**SYDNEY OLYMPIC PARK AUTHORITY
DESIGN REVIEW PANEL – ADVICE SHEET**

Project	Sites 2A and 2B – Australia Ave, Sydney Olympic Park	
Presentation / Review Date	3 September 2019	
Panel Present	Ingrid Mather	JMD Design (Chair and representative of the Government Architect)
	Caroline Pidcock	Pidcock Architects
	Michael Harrison	Architectus
COI Declaration	None	
Also Present	Alix Carpenter, Dylan Sargent, Richard Seaward, Sally Hamilton (SOPA) Daniel West and Candice Pon (Ethos Urban) Bassam Afflak, and Greg Hynd (Ecove) Annetta Mitrovic and James Fitzpatrick (Fitzpatrick + Partners) Clifford Dean and Michael Barnett (Arcadia)	
Presenters	James Fitzpatrick (Fitzpatrick + Partners) Michael Barnett (Arcadia)

DRAWING
PHOTOMONTAGE SHEET 05 - MARKET
PLACE

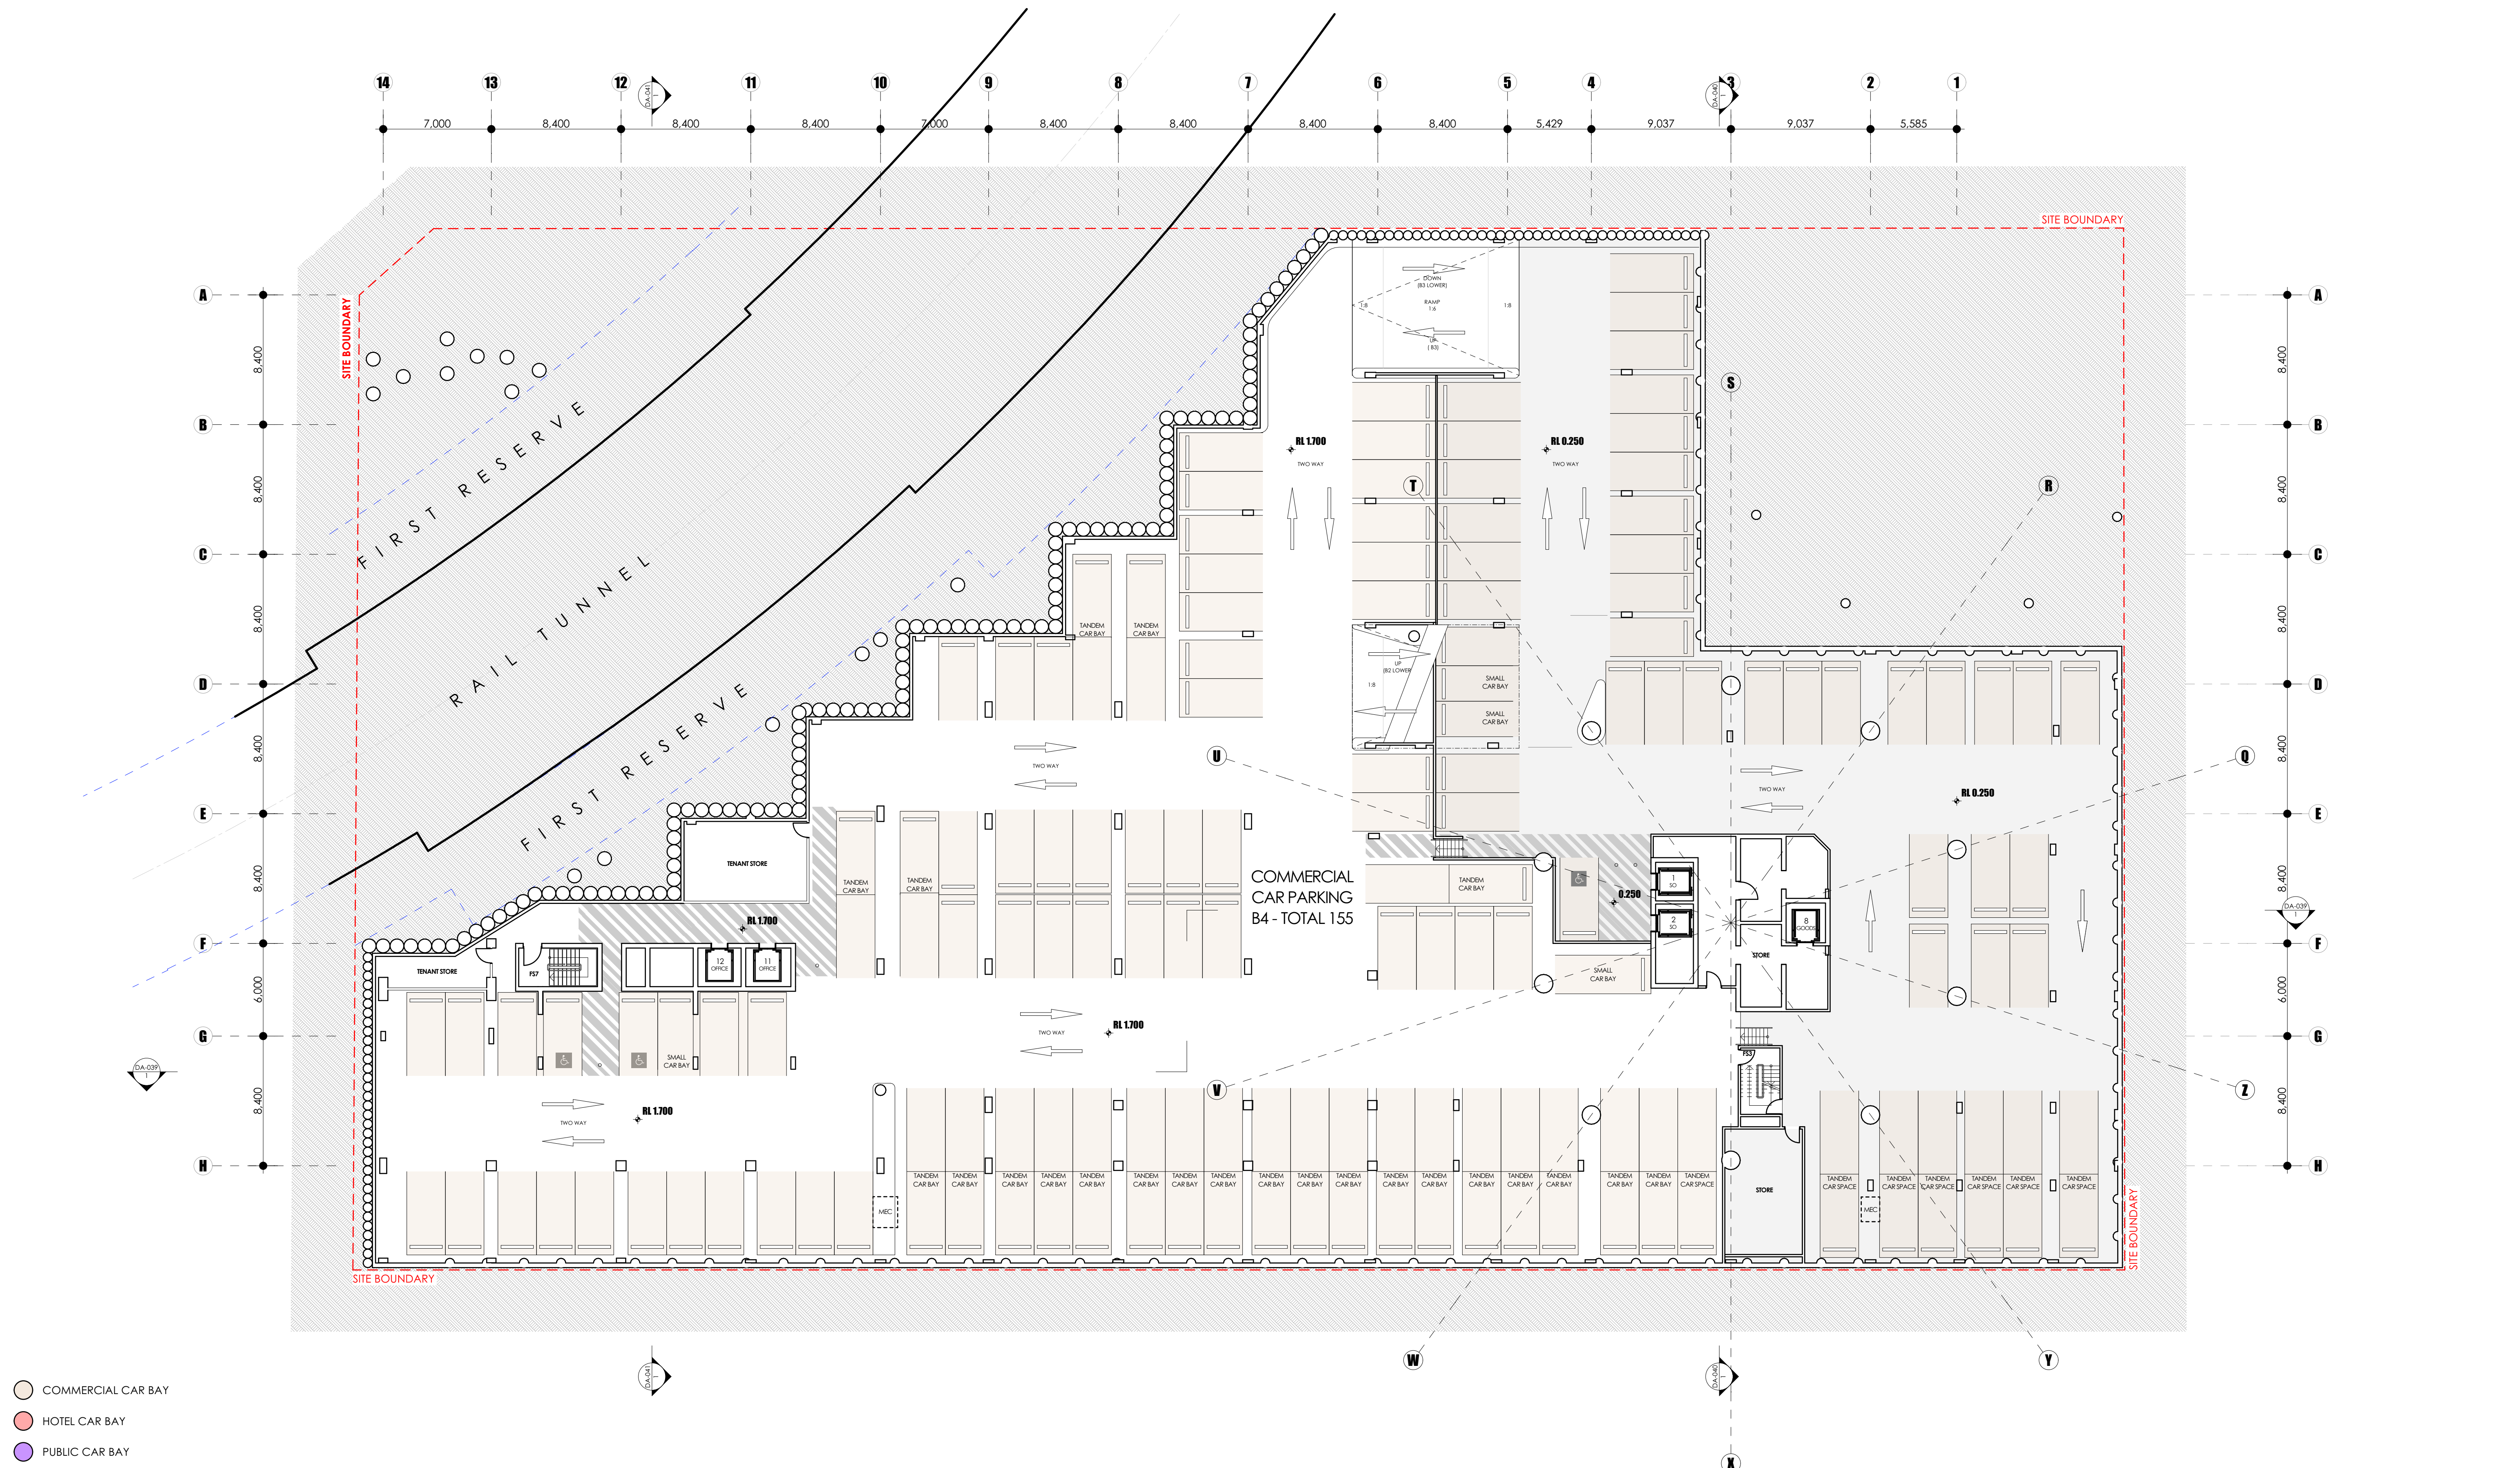
It was also noted that the amendments to the ground floor of building 2B could impact on the micro-climate of the Market Place by increasing wind tunnelling, given that the seating area would change from an internalised area to an external area exposed to the elements. It was noted that a wind desktop study was undertaken for the DA lodgement. However, it is considered that further wind tunnel testing should be undertaken to the Market Place now it will be exposed to the elements; specific consideration should be given to the exposure of the site to westerly winds.

2. The impact of wind and microclimate on the Market Place of building 2B should be further considered as a result of the design amendments to the ground floor of building 2B, comprising the externalisation of the seating area;

Circulation_Pedestrian

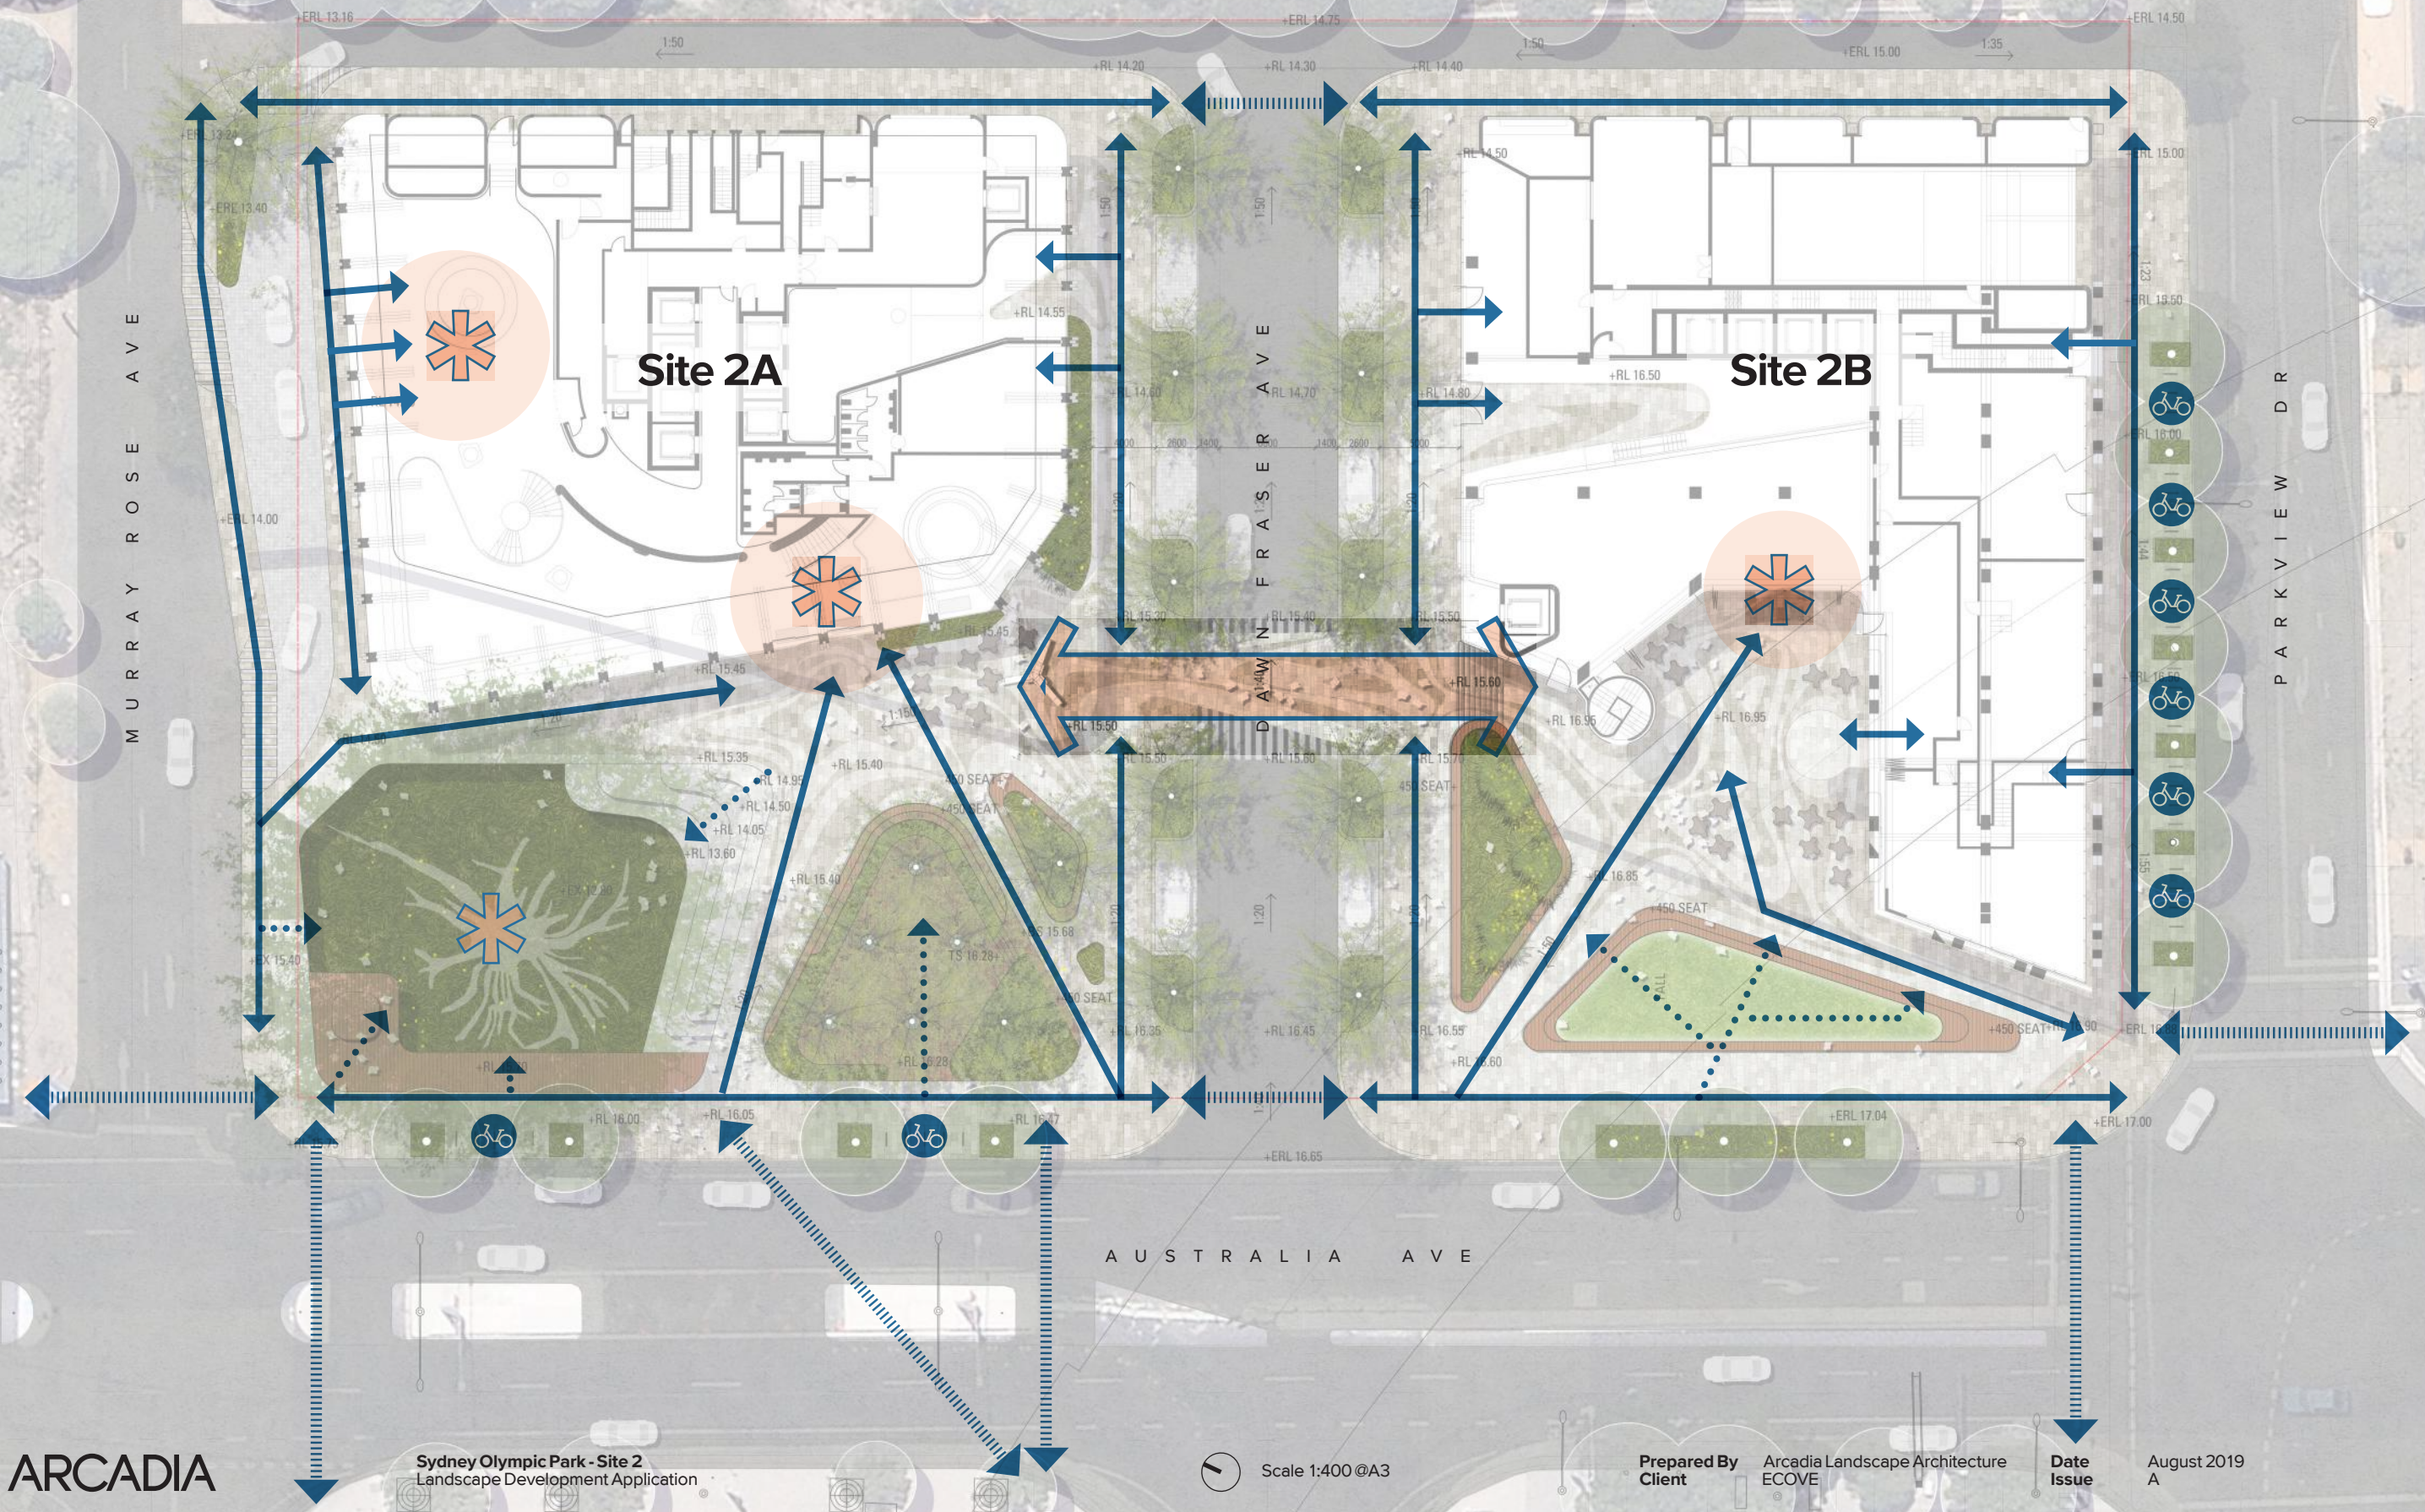
It was noted that a stronger pedestrian priority threshold between Australia Avenue and Dawn Fraser Avenue should be considered. Indicative crossings should be shown on both the North and South side of Dawn Fraser Avenue with Australia Avenue. It is considered a stronger connection between the North East corner of the junction of Australia Avenue and Dawn Fraser Avenue should lead to the entrance to site 2A. The dominance of the secondary route to the entrance between the fig tree and decked grove should be reduced commensurate with its hierarchy as a secondary route.

1. The hierarchy of circulation to the public realm requires further consideration. Desire lines from key crossing points should be utilised in the first instance. The hierarchy of pavement widths should also be reviewed and additional greening and canopy cover to replace the paving;
